**Consultation Response from KC,
Highways Development Management****2025/93464 Spinksmire Mill, Huddersfield Road, Meltham, Holmfirth, HD9 4AN****Demolition of existing building and erection of industrial building****Date Responded: 12/06/2026****Responding Officer: Ryan Kinder****Responding Ref:K3-15/11**

2025/93464 Spinksmire Mill, Huddersfield Road, Meltham.

RECOMMENDATION: Objection- further information required.

Proposed site plan – ref 1546-LRC-ZZ- XX-DR-A_102-REV P02 dated 24/04/26

P02	SITE SECTION LINES ADDED.	IR	24/04/26
P01	BOUNDARY LEGEND AND IMAGE ADDED.	IR	04/02/26
REV	DESCRIPTION	BY	CHKD DATE

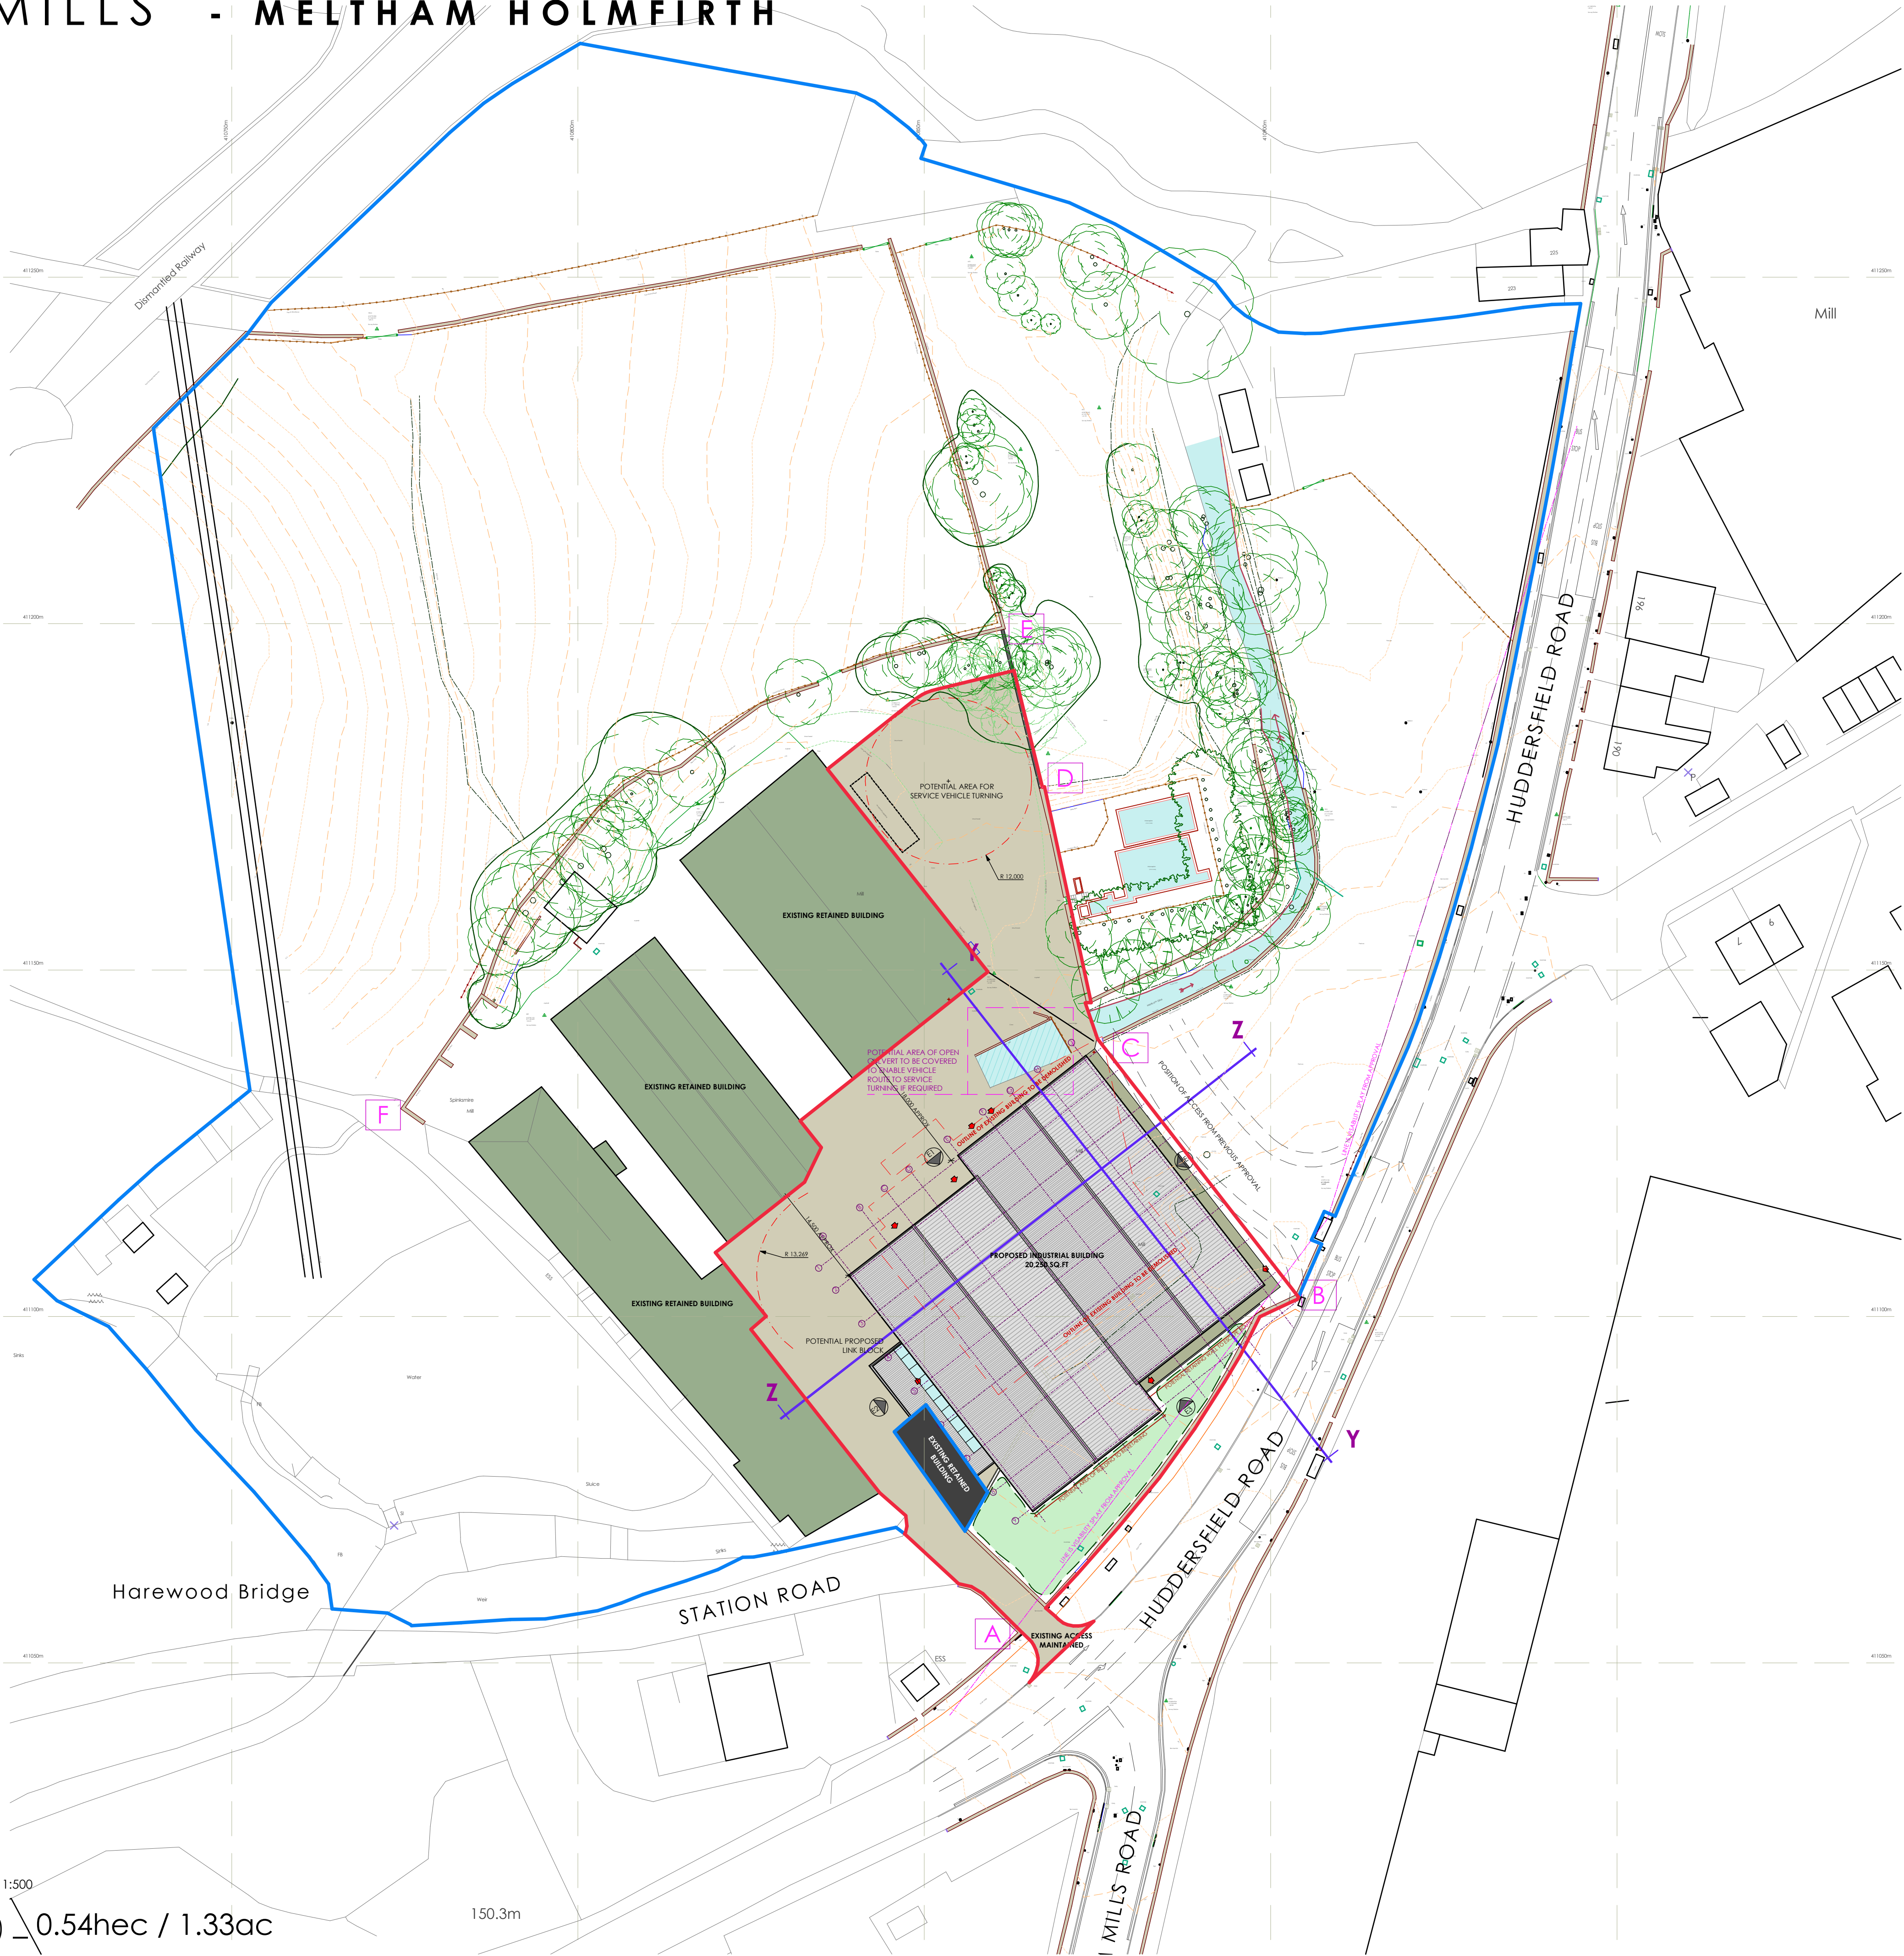
The site is to be access via Station Road into the site which is currently unadopted. It is acknowledged that the site access is existing and established, however given this proposal is for a new development it is considered that the existing site access should be brought up to a modern standard for industrial use as far as reasonably possible. The current arrangements falls short of what would be required for this type of development, in addition a recent housing development has been constructed adjacent to the site which shares the same access. Given these factors it is considered a necessity for a scheme to improve the current access is required from a highways perspective.

The proposed service yard to the rear of the site will need to be accessible by suitable vehicles that utilise the current business, again no information on vehicular access including vehicle types or swept paths has been provided including negotiating any onsite parking.
